Our Ref: 2018/92804

**TOWN AND COUNTRY PLANNING ACT 1990
TOWN AND COUNTRY PLANNING (GENERAL PERMITTED DEVELOPMENT) (ENGLAND)
ORDER 2015 – SCHEDULE 2, PART 1, CLASS A.1 (g)
AT: 30, Marten Drive, Netherton, Huddersfield, HD4 7JX
Prior notification for single storey rear extension**

PROPOSED
(SAME OVERALL
SIZE AS EXISTING)

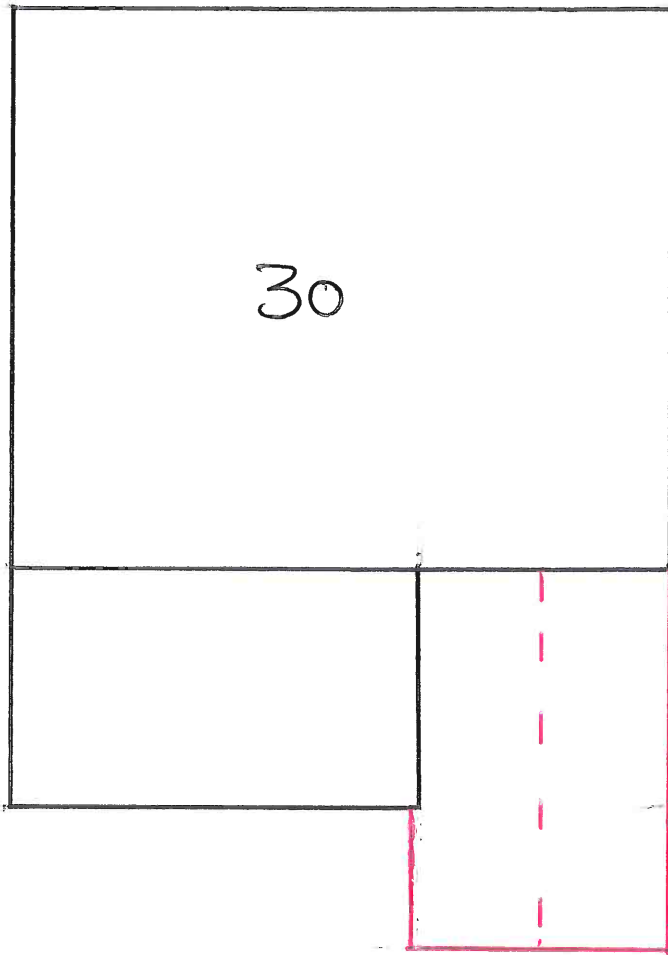
The proposed single storey extension is considered **not** to benefit from a general planning permission under Class A of Schedule 2 of the Town and Country Planning (General Permitted Development)(England) Order 2015 (as amended) by reason of the proposed enlargement adjoining an existing enlargement to the original dwellinghouse and the combined enlargement exceeding this limitations set out in paragraphs (ja) and (j) of Class A.
